Recommendation Report for Planning Permission for Works or Extension to a Dwelling

REF NO: AW/10/19/HH

LOCATION: 31 Queens Fields West
Aldwick
PO21 5SG

PROPOSAL: Proposed two storey extension with open fronted car-port at ground level

Proposed Elevations

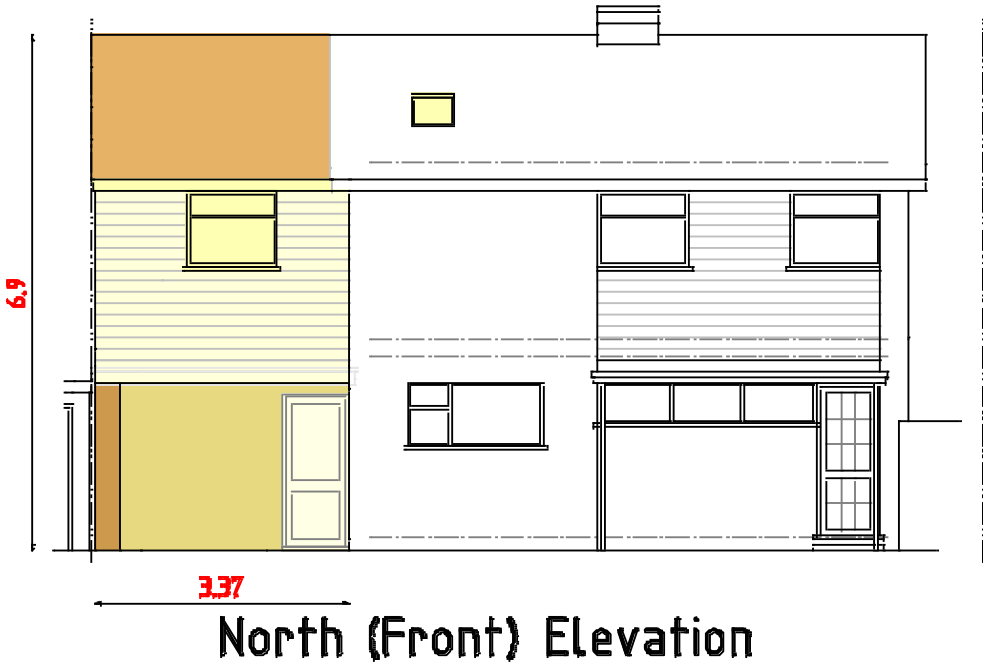
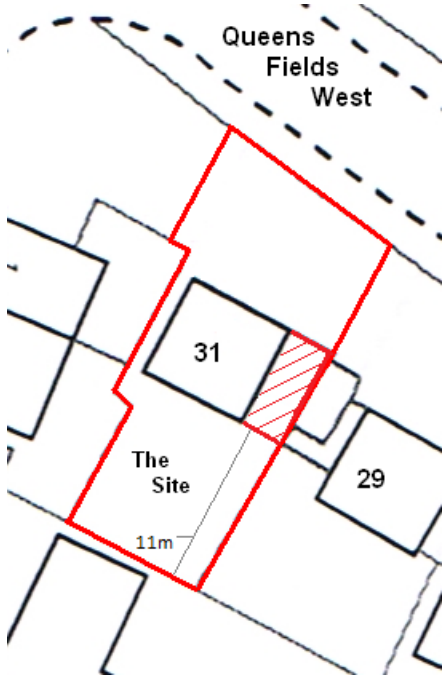
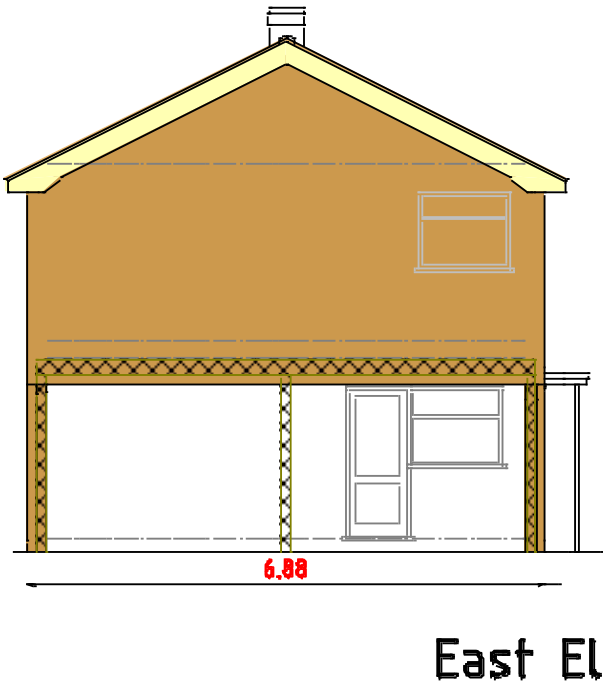
The two storey extension is sited to the eastern elevation and is therefore clearly visible from the street scene.

The extension appears well integrated and subservient to the host dwelling with materials used to match that of the existing dwelling. The proposal will not extend beyond that of the principal elevation and therefore retain 8m to the front boundary. The surrounding area consists of properties of a similar style and design however the proposal is not considered to appear out of keeping with the locality.

The two storey extension will run along the full side elevation of the dwelling and have a width of approximately 3.4m. It will be constructed with a height to match that of the existing dwelling. The ground floor will serve as an open fronted car port with a bedroom above.

The two storey extension will be constructed up to the boundary to the east. The neighbouring property has a single storey garage and therefore with around 3.75m retained to the side elevation of No.29 the proposal is not considered to appear adversely overbearing. The neighbouring property does have a window to the side elevation however again due to the separation, any overshadowing is not considered significant in which a refusal is justified.

There will be no windows to the side elevation of the host dwelling however there will be an additional window to the front and rear elevation. Whilst the window to the rear may give rise to some views over the garden to the neighbouring property although it is not considered they would be additional to that which can already be achieved. Due to the siting of the properties to the rear, it is not considered there will be any adverse overlooking as a result. The window to the front will overlook the street scene.
